DECISION DELEGATED TO DEVELOPMENT MANAGER

Application No: H16-0699-21 **Applicant:** Poundland Ltd.

Proposal: Proposed Signage

Location: B And M Stores Ltd Winsover Centre 14 - 16 Winsover Road

Drawing Title
Proposed Front & Rear Elevations

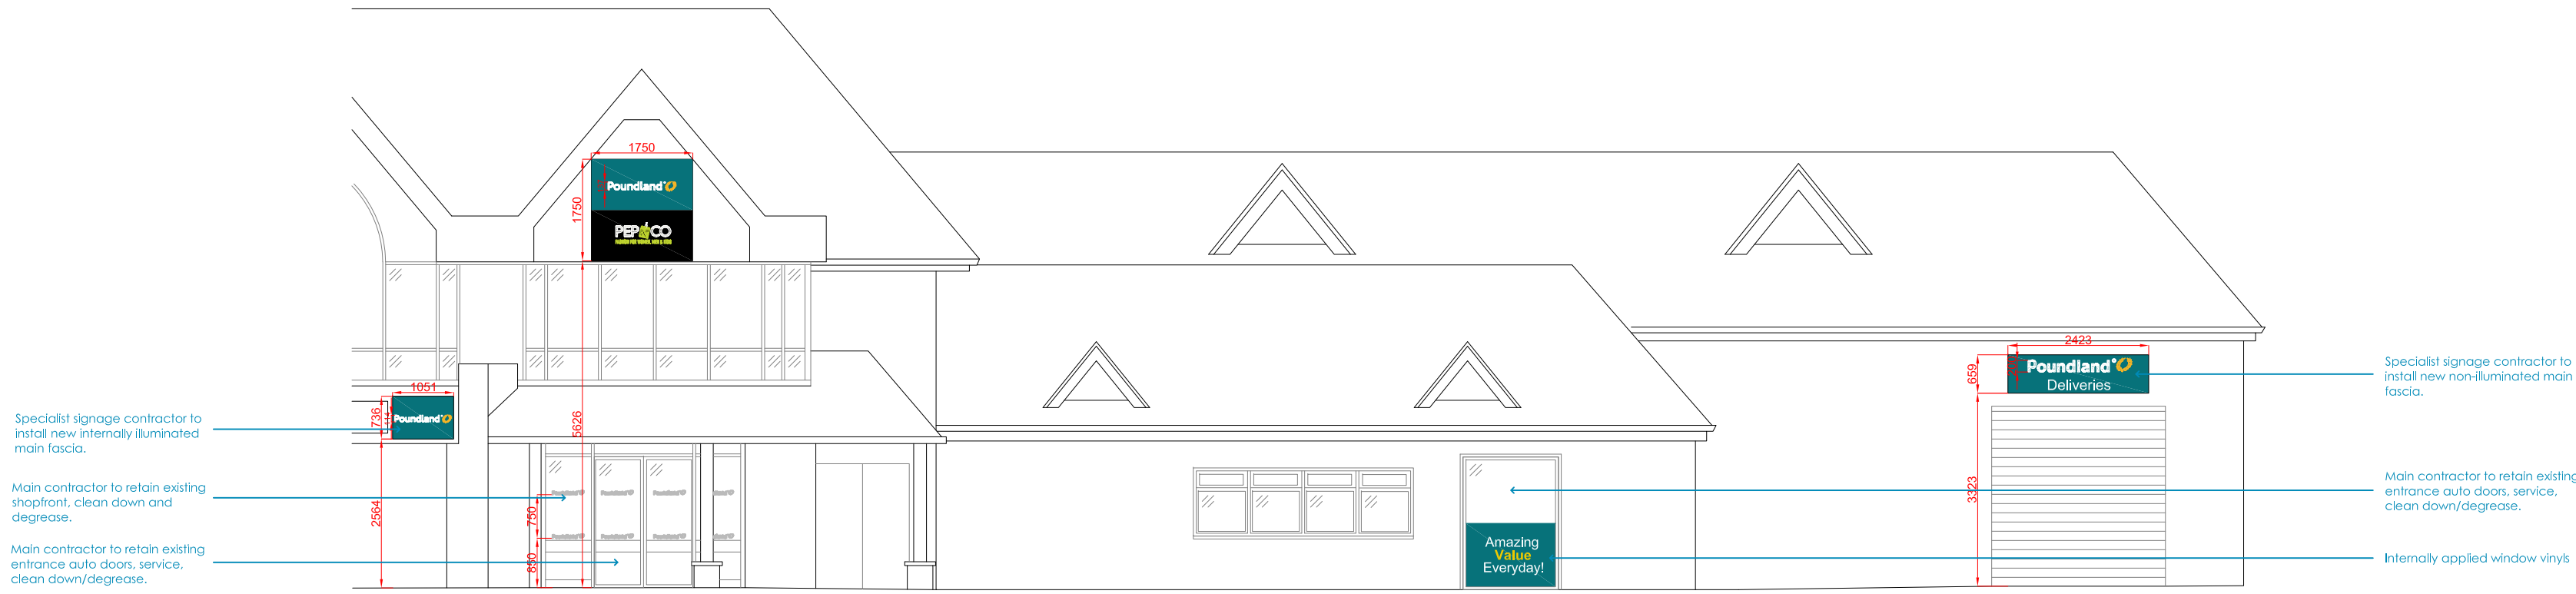
- Highlights Policy 26 in the SELLP (2019) regarding the blanking out of shop windows with vinyl films. The dead frontage will have an affect on the footfall. Also contrary to Policy 3.

The proposal is for various types of signage. They include an internally illuminated main fascia and internally applied window vinyls to the rear elevation. To the front elevation, 2 no. internally illuminated main fascias and signage on the automatic doors at the entrance. There will also be a non-illuminated main fascia at the delivery bay and a internally applied window vinyl to the automatic door.

The signage is typical of Poundland Stores and is considered to be an appropriate form of advertisement. There is currently existing vinyl along the rear elevation of the store along Winsover Road and the proposed vinyl would be no more detrimental, perhaps arguably better than the unattractive rear of stacked shelves being visible to passers by which would create no more of an active frontage than the vinyl.

The majority of the signs would be internally illuminated. However, it is subtle and would not materially harm the amenity of the neighbourhood.

In this instance, Policy 26 is not considered to be directly relevant to this application as the store is not situated in the Primary Shopping Frontage within Spalding.

The proposal is considered to satisfactorily accord with Policies 2 and 30 of the South East Lincolnshire Local Plan, 2019.
